From: William Clark
To: David Margolis-Pineo
CC: Jean Fraser
Date: 6/10/2015 11:39 AM
Subject: 91 Industrial Way Existing Conditions Plan Survey Review 3 10 2015
Attachments: Industrial Way No 91 Existing Conditions Survey Review 6 10 2015.PDF

They tied into State Plane Coordinates as well as the City of Portland Vertical Datum.

EXISTING CONDITIONS PLAN
 OF:
LOT 5 INDUSTRIAL WAY
 INDUSTRIAL WAY
 PORTLAND, ME 04103
 FOR:
DEERFIELD 91 INDUSTRIAL, LLC.
 1 CANAL PLAZA
 PORTLAND, ME 04101

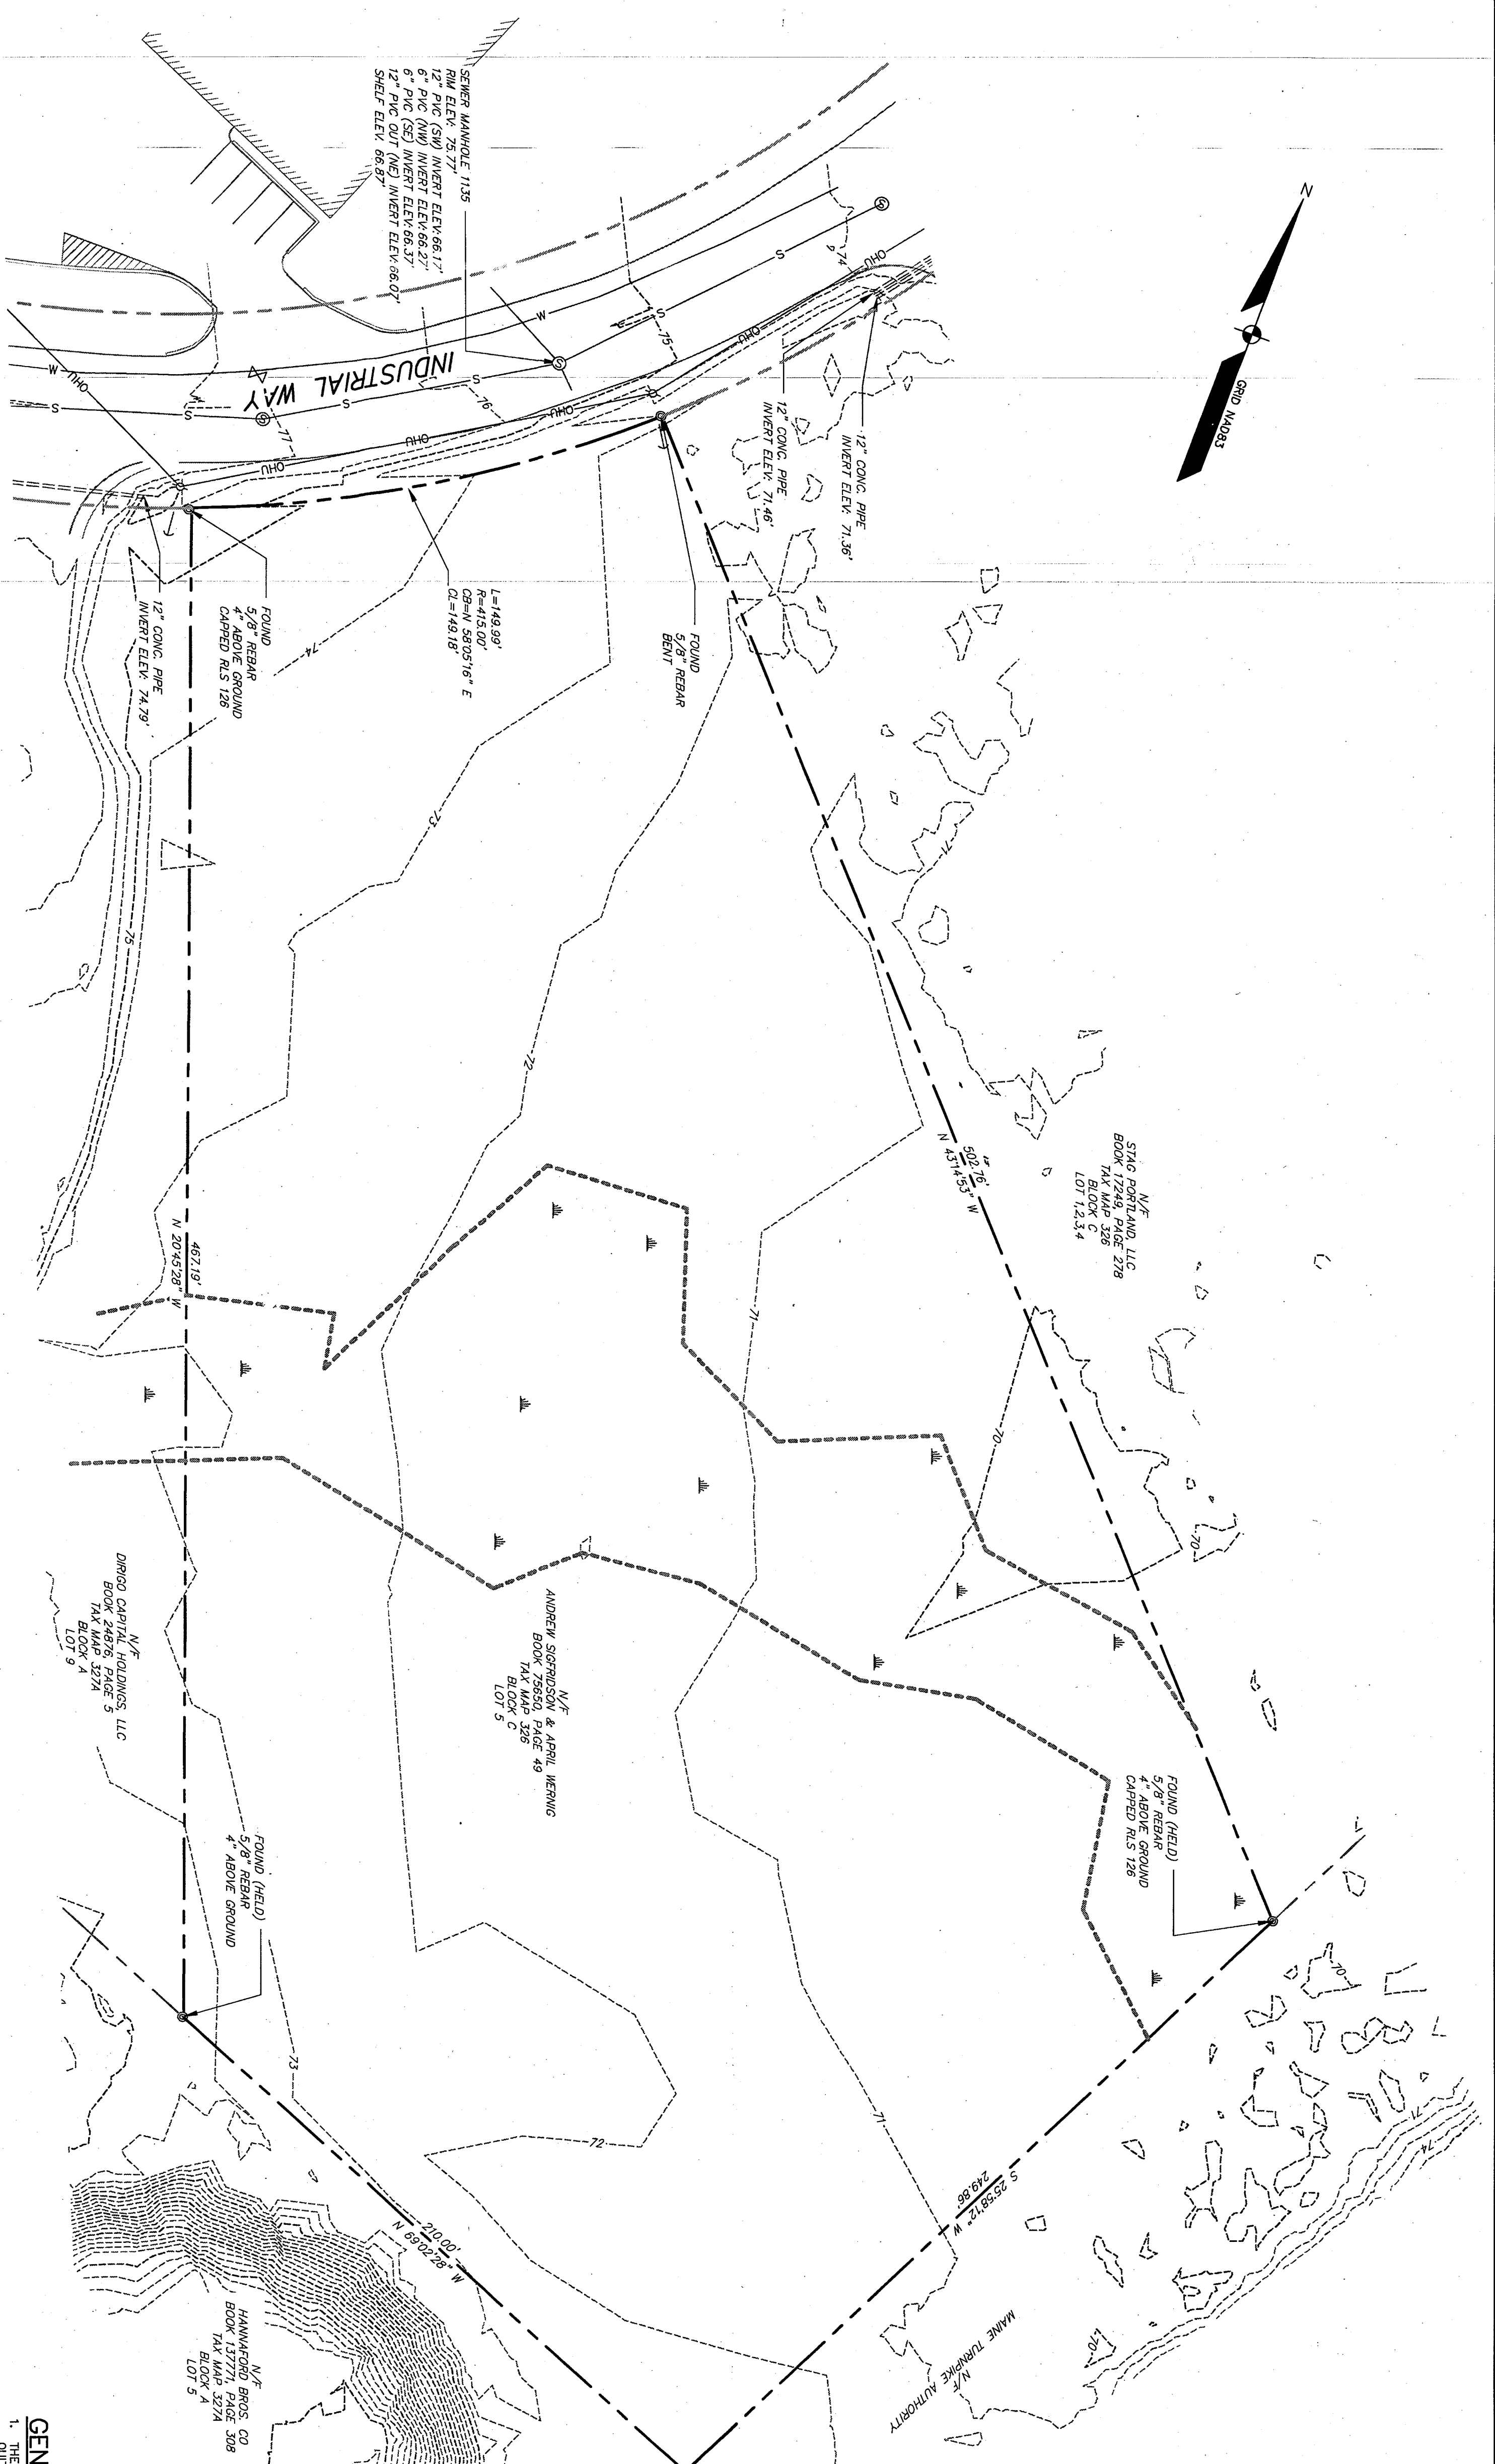
Please add

1. State Plane Coordinates at all corners.
2. Chord Bearing and Distance for curve along Industrial Way.
